Planning Hybrid ref. Y3/22/OUT

I would like to register an **objection** to the hybrid application Y/3/22/OUT for:

Full planning for phase 1 of the proposed development for 30 dwelling and outline planning permission for a further 110 to the West of Bilham Rd.

PROPOSED 1.5m FOOTWAY (SUBJECT TO TREE
SURVEY AND ROOT IMPACT ASSESSMENT) TO
ENSURE SAFE CONNECTION WITH ALLOTMENTS
AND PUBLIC FOOTPATH 144

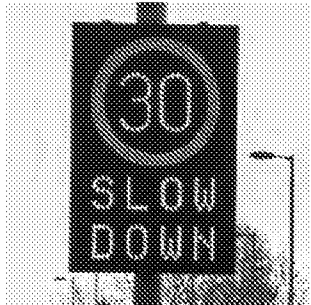
1.The proposed pavement from Taylors Close to Grevatts Lane West, which has been mentioned before in earlier applications.

A proposed 1.5 metre pavement/ cycle track has already been **refused** by both ADC and YPC. Please check your records in relation to the earlier Little Meadow applications.(Mr Hyam's field).

The area of verge does not belong to WSCC as has previously been advised but allegedly ignored.

They only own approx.1m to the highway, the rest is owned by the adjacent properties, who would be required to sell their verges. I would also like to point out that the proposed width would include part of my existing driveway and that it would be necessary to park on the proposed pavement for access which is understood unlawful. No risk assessment appears to have been undertaken in relation to the

Hobbs Corner bend where vehicles regularly ingress into the verge to avoid hitting one another. Cyclist racing down that stretch in prospect has not been considered either. Drainage from the road and into any ditches/verges owned by householders has also not apparently been considered. Neither has such a pavement been considered in terms of the heritage access/asset of Hobbs Court and Hobbs Farmhouse and in terms of the *refusal* of the Little Meadow proposal and comment from the conservation officer regarding the pavement, which advised that it was not acceptable as **urbanisation**. If all these aspects continue to be ignored, they will not go away or resolve safety issues. It is perhaps likely to result in a legal challenge/safety issues/ raised at a higher level.
